CITY OF ALBUQUERQUE

March 2, 2017

RE: Aviation Center of Excellence Drainage Report
Engineer's Stamp Date: 2/8/17
Hydrology File: M16D024N

Based upon the information provided in your submittal received 2/8/17, the Drainage Report is not approved for Grading Permit. The following comments need to be addressed for approval of the above referenced project:

Sheet X Of X
G-006

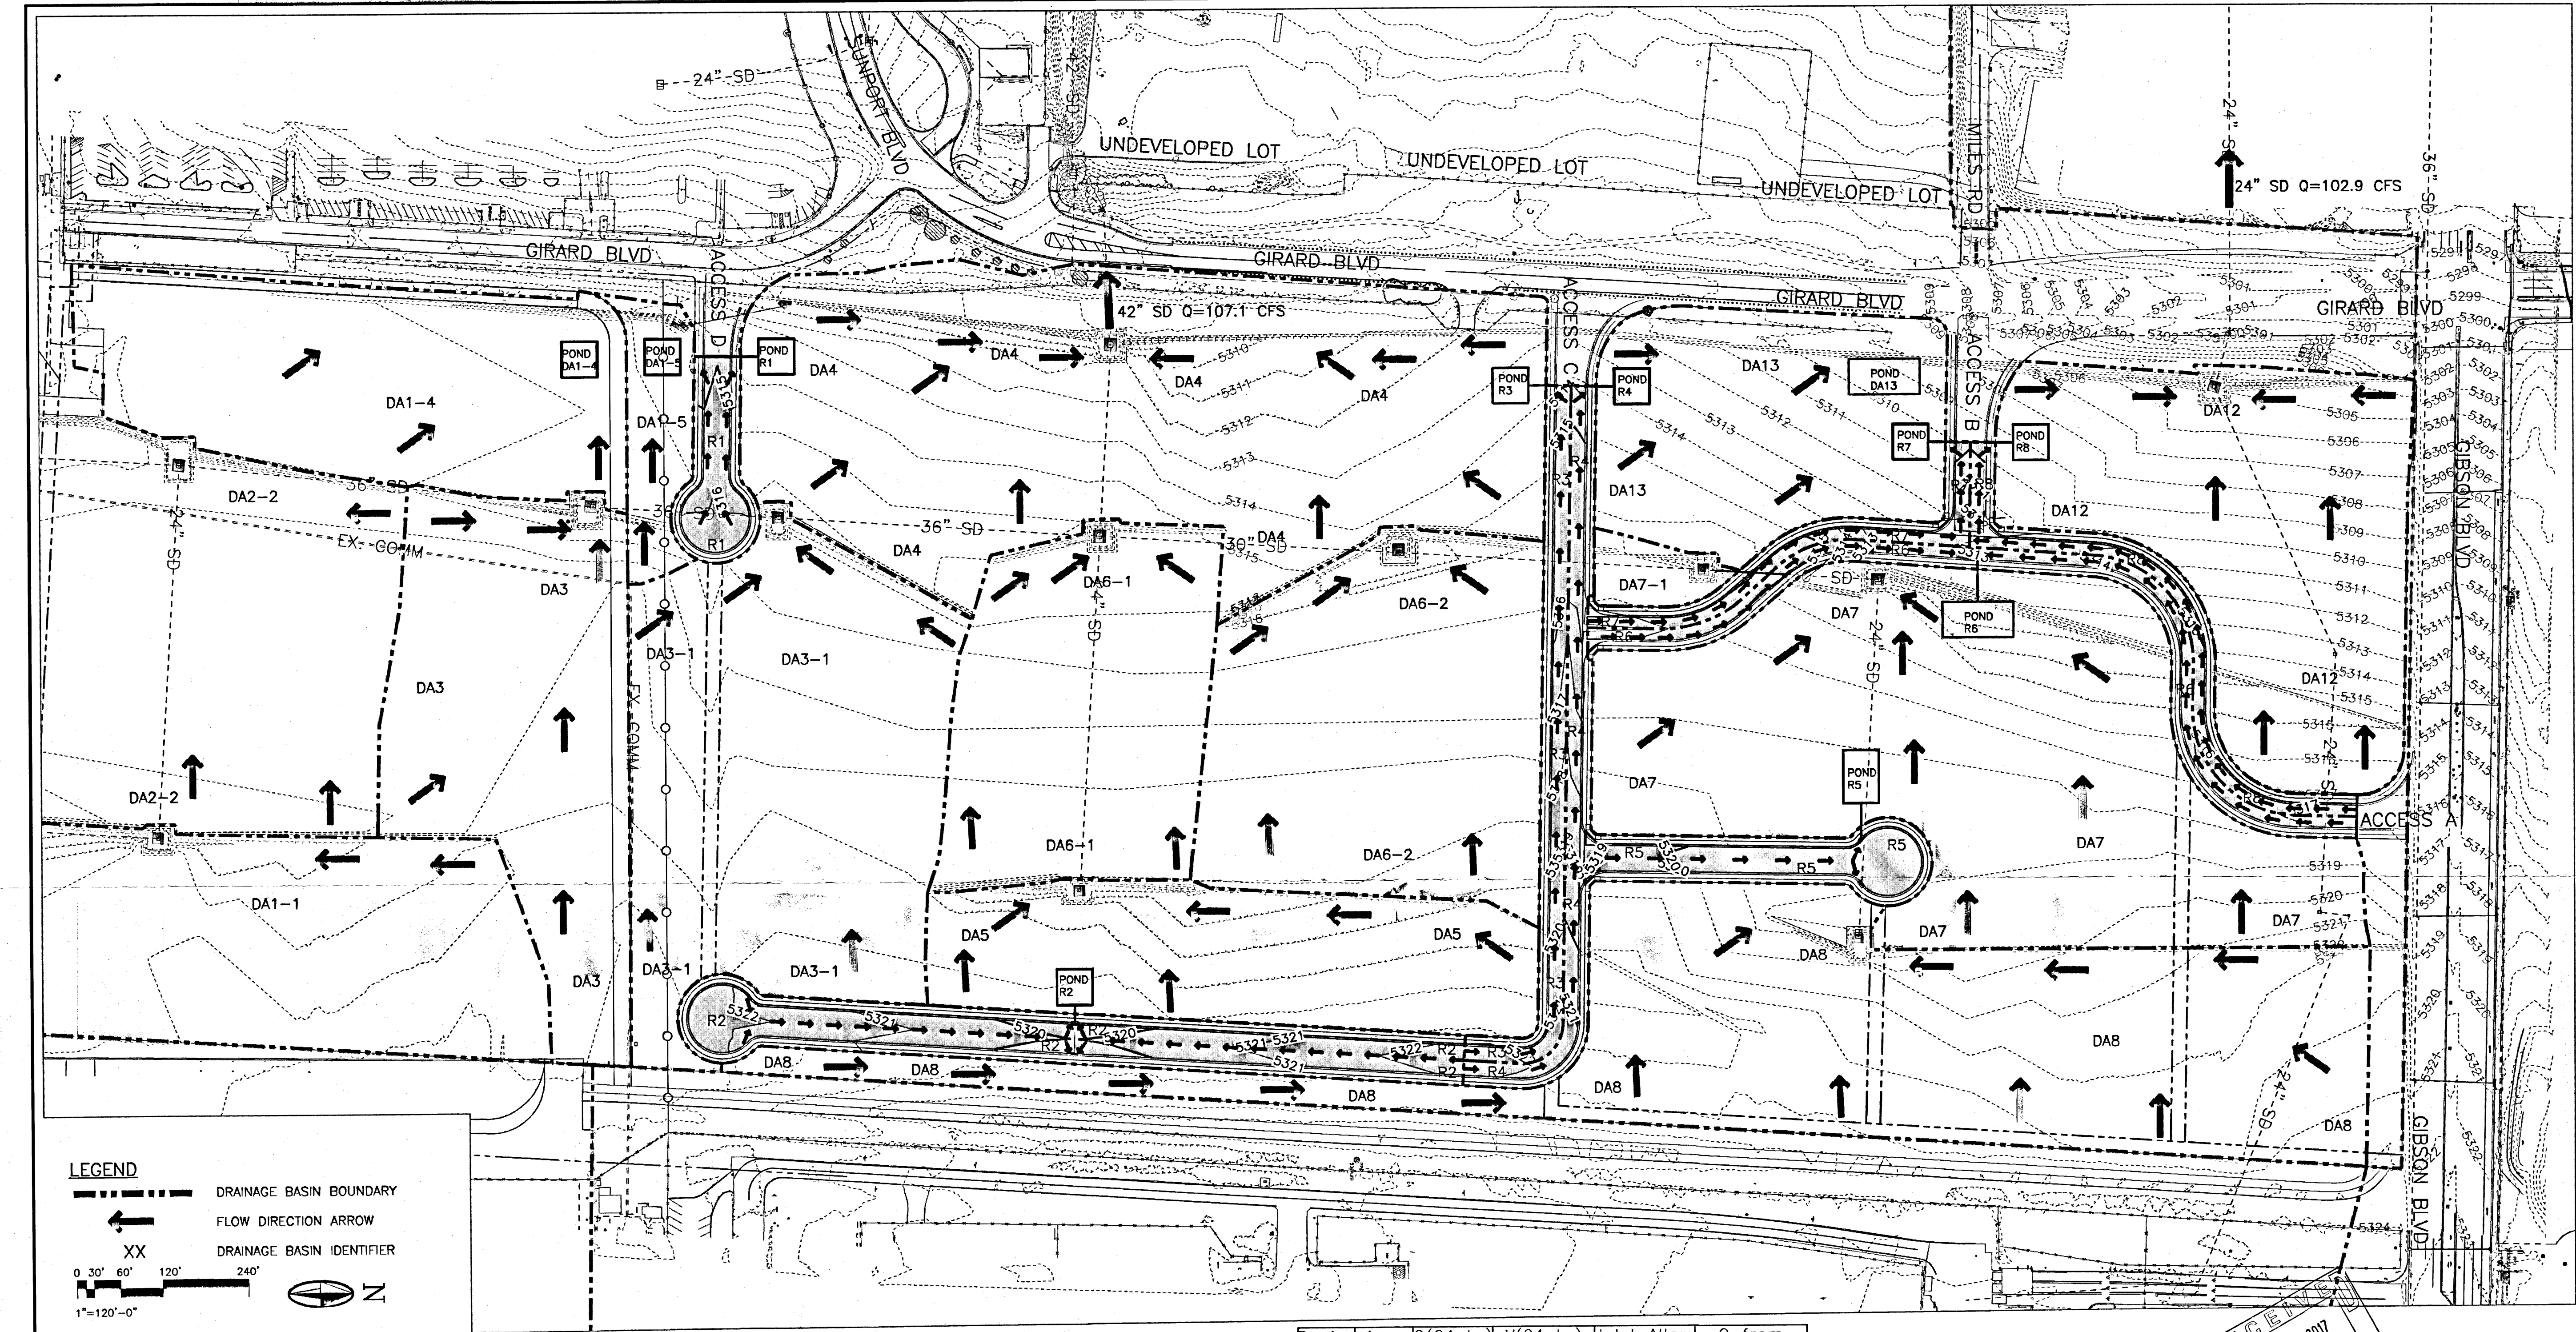
1. The first flush ponds need to be designed as part of these improvements. This information includes pond dimensions, bottom of pond, side slopes, maximum water surface elevation, and pond volume.
2. Waterblocks are necessary where the private roads meet public roads (Girard and Gibson).

It is Hydrology's understanding that these are low-speed, local roads, and the use of dip sections and curb cuts in accordance with standard drawing 2422 is acceptable. If you have any questions, please contact me at 924-3695 or dpeterson@cabq.gov.
